From: Laura Gibbons
Sent: 10 May 2018 14:11
To: Planning.Responses
Subject: RE: Planning Consultation on M/52/18/DOC

Engineers comments regarding condition 3- surface water drainage

APPLICATION M/52/18/DOC

Site Address: 08 Elmer Road Middleton on Sea PO22 6LJ

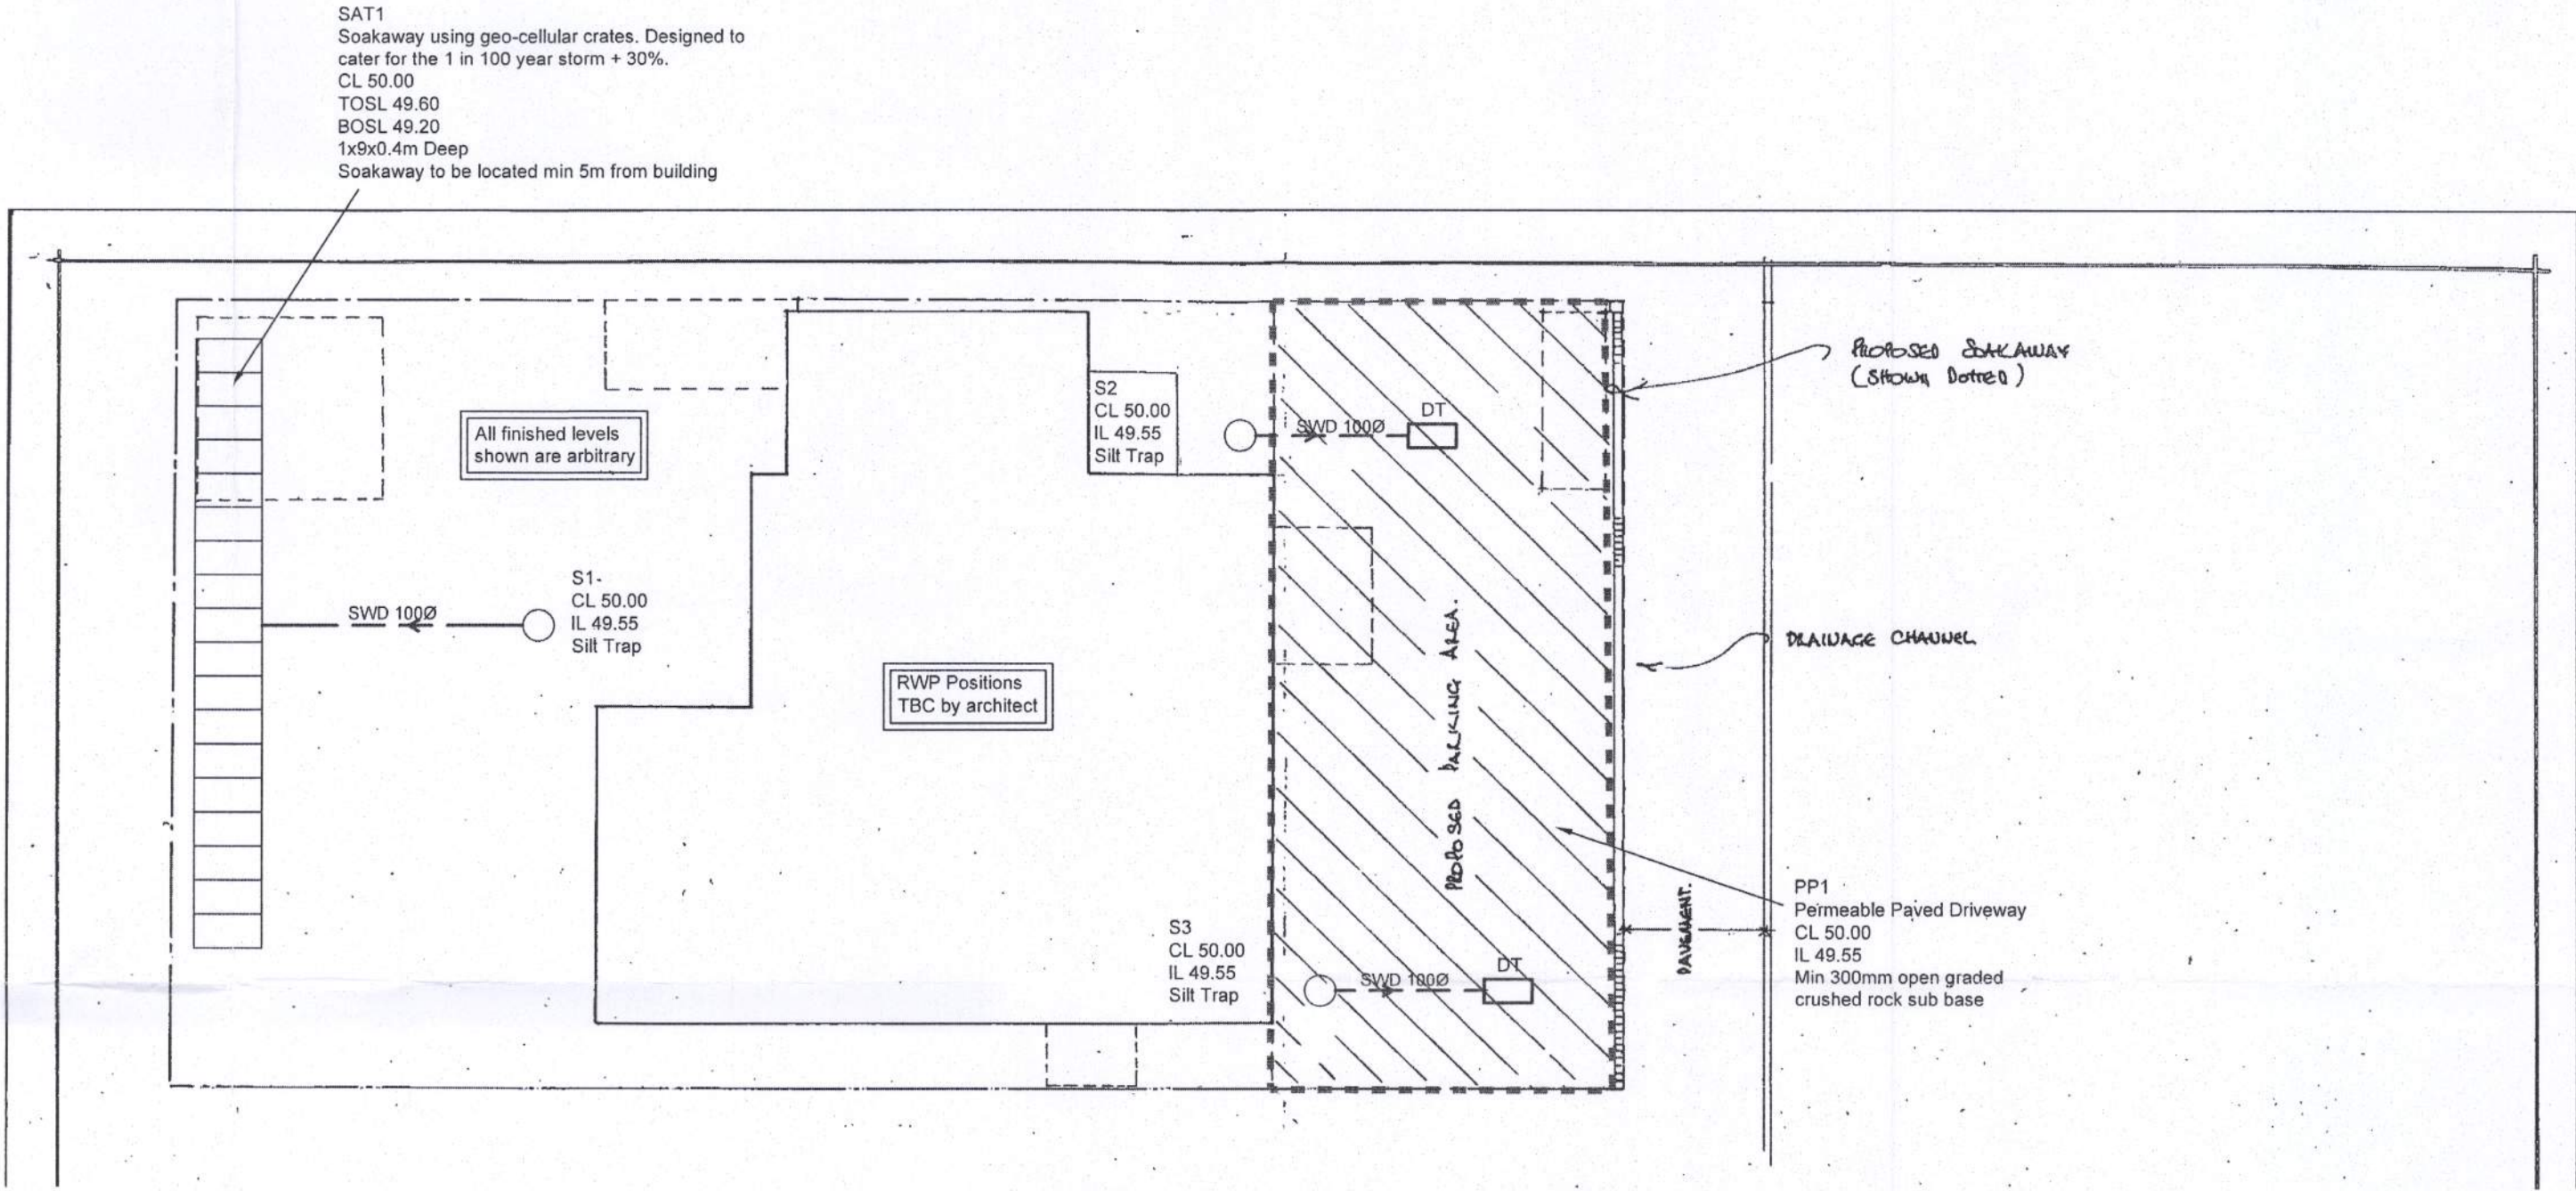
- Please provide calculations for the proposed soakaway, currently 2 sets of porous paving calculations are provided.
- The drainage layout currently shows the invert level of the porous paving to be 50mm below the finished level. Please correct.
- Please provide construction detail drawings of silt traps, porous paving and soakaways.
- As the proposed porous paving area is also designed to take rainfall water a minimum of 5m easement from the building will be required.
